TO: BCL Enterprises, Inc.
FROM: Megan Jones, Current Planner
RE: Proposed Minor Amendments – 201 Unser Blvd NW

I have reviewed the application materials for the proposed minor amendment to the Nuevo Atrisco Apartment Complex for a shade structure in the existing dog park. I am requesting revisions to the Justification Letter in order to meet requirements per the criteria in IDO Section 14-16-6-4(Y)(2).

A1 SITE PLAN 1" = 20'-0" 0 10' 20' 40'

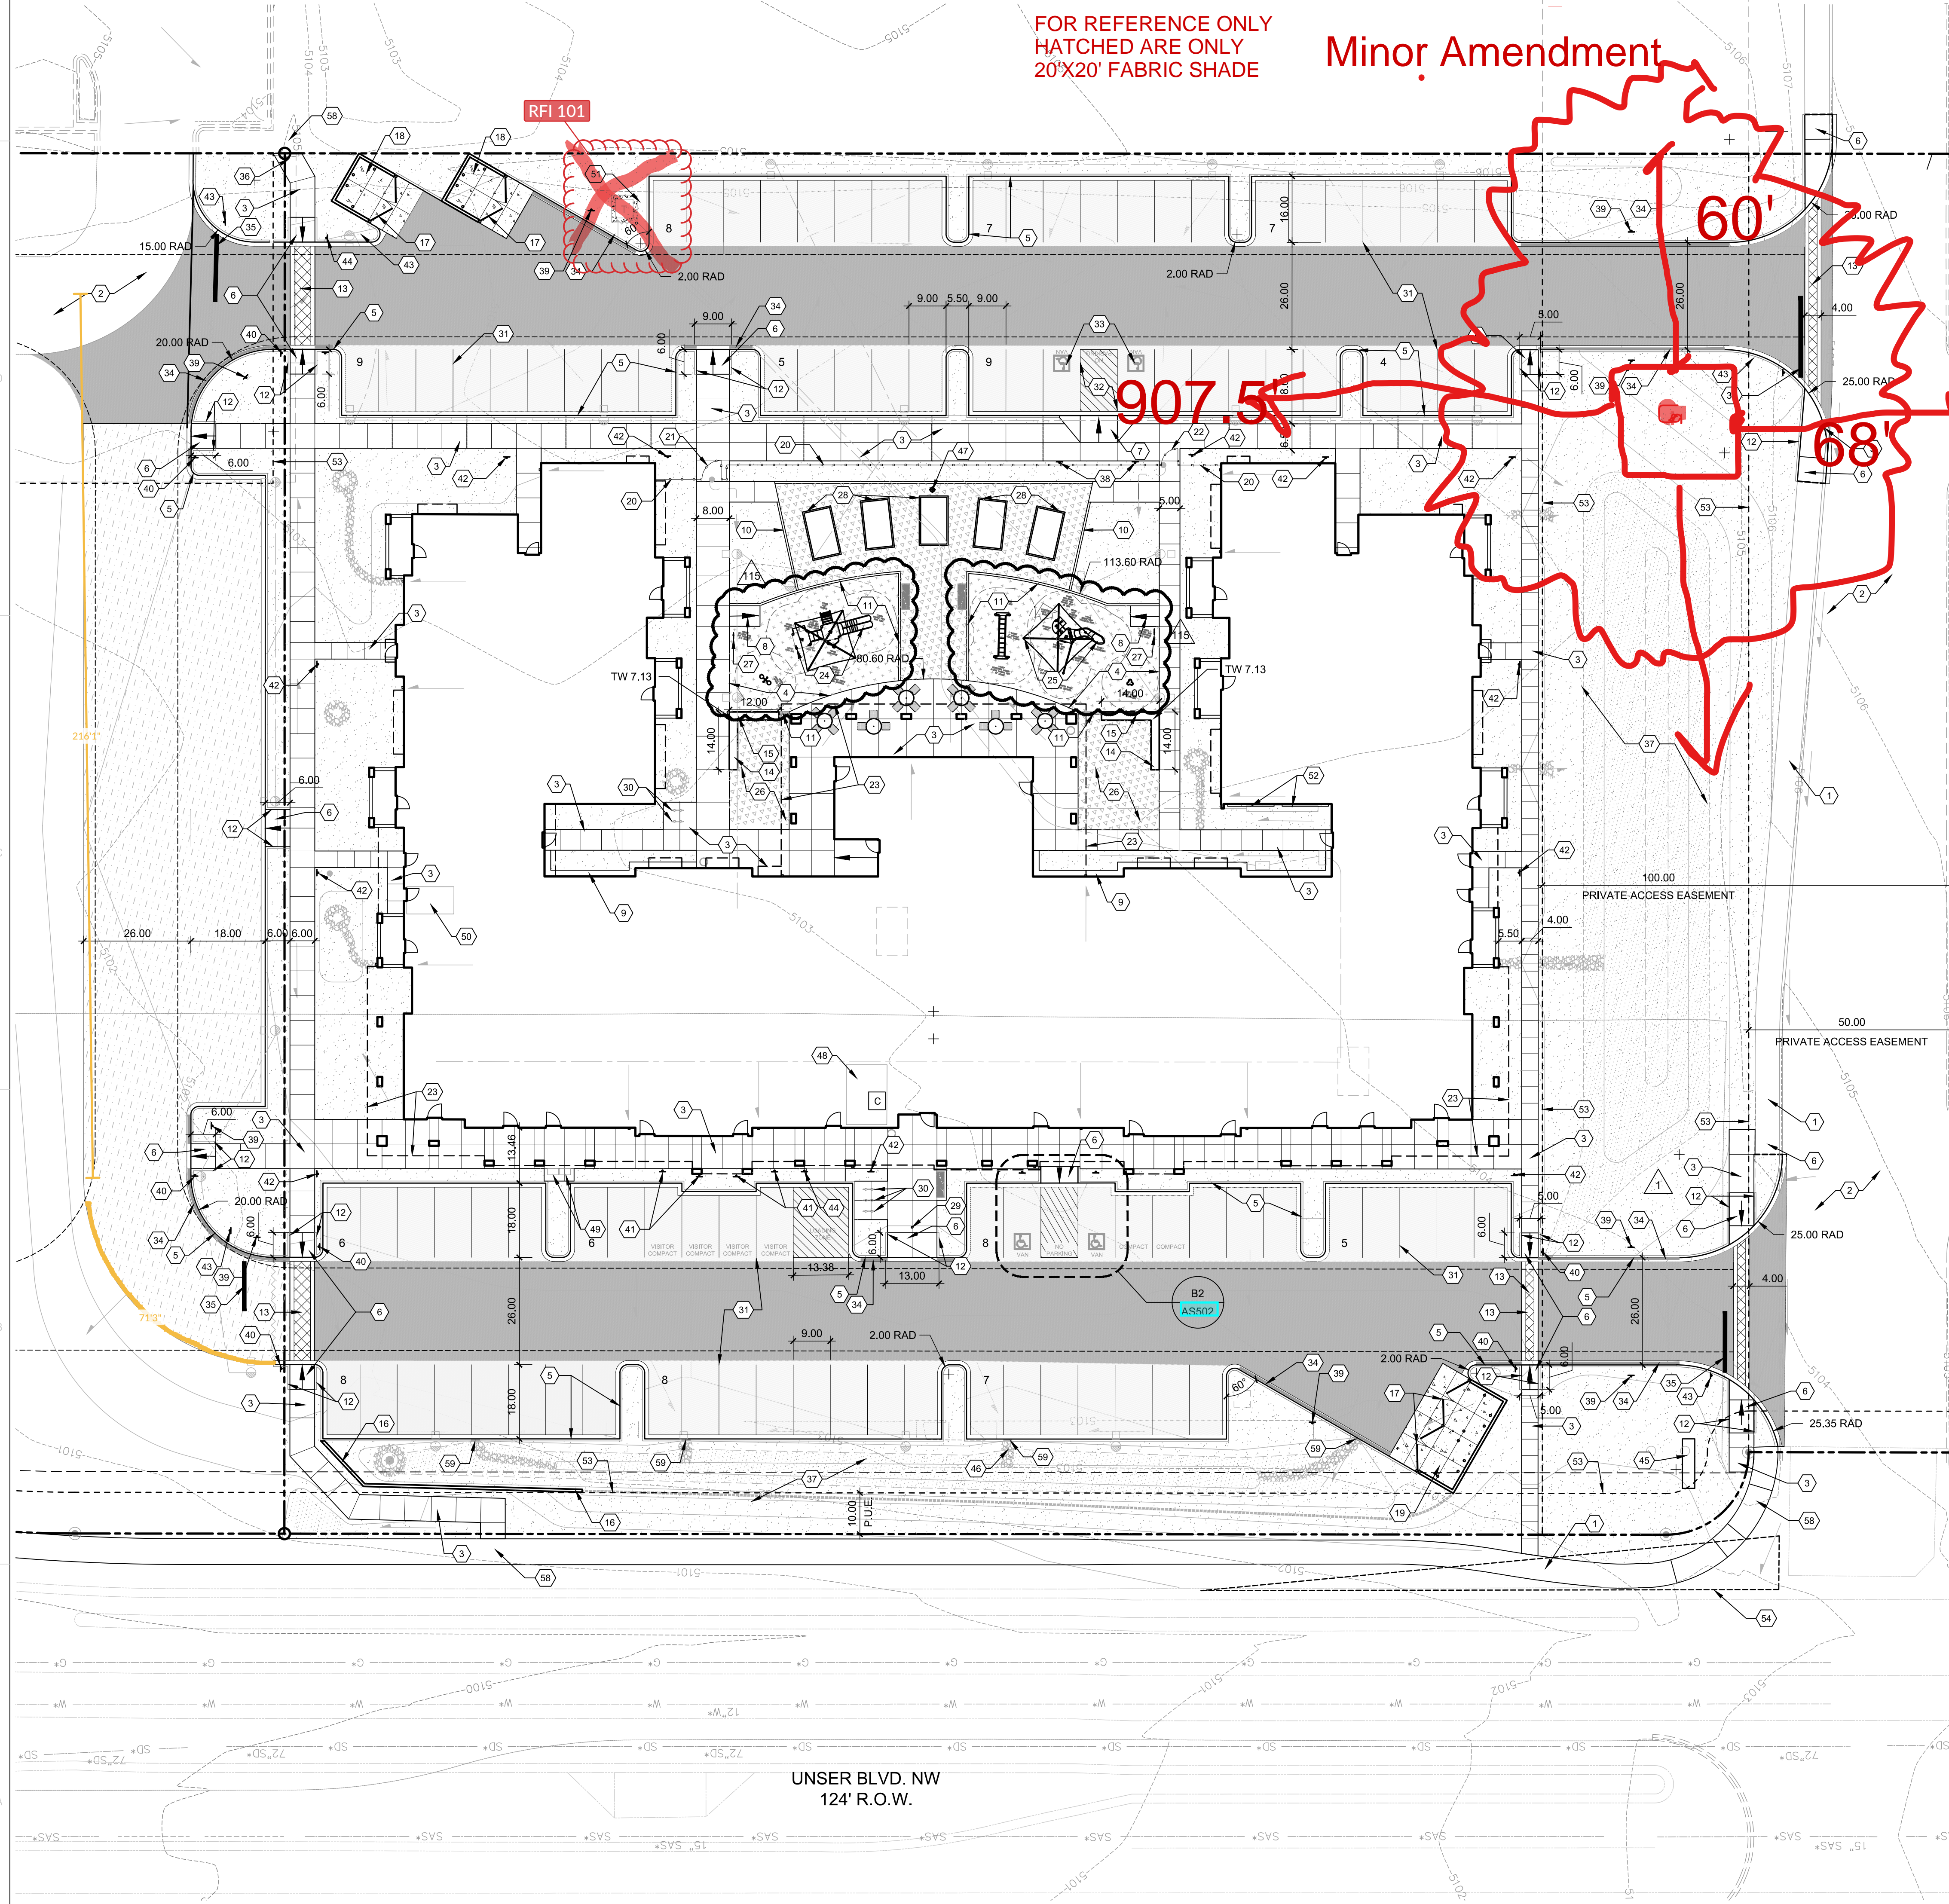
4. Please label the site plan/drawings that you will be amending and title them with Minor Amendment and the month/year. Make sure that all changes are clouded, which seems you have done.

DRAWING DESCRIPTION:
 ELEVATIONS AND DETAILS

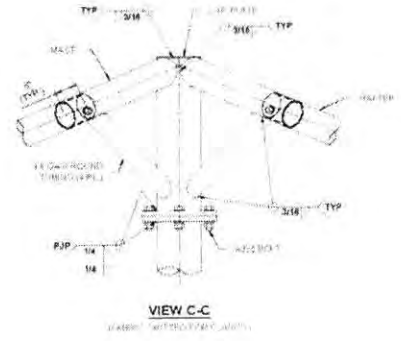
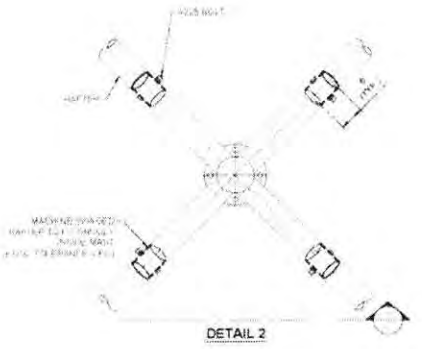
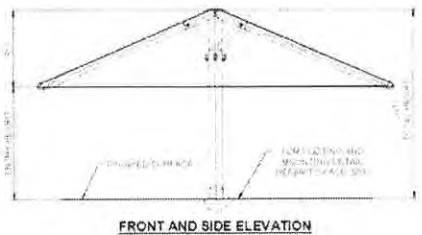
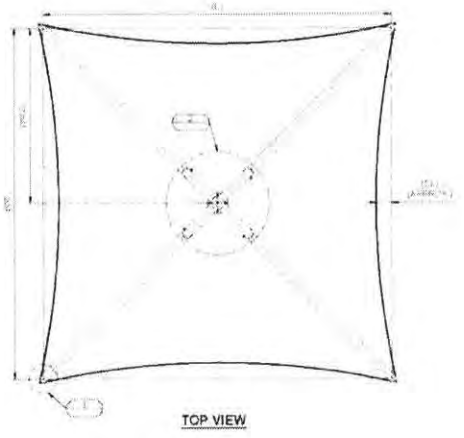
3. Please submit a new elevation sheet with the photographs. The one included in your submission is very distorted and in black ink. A color copy will be better.
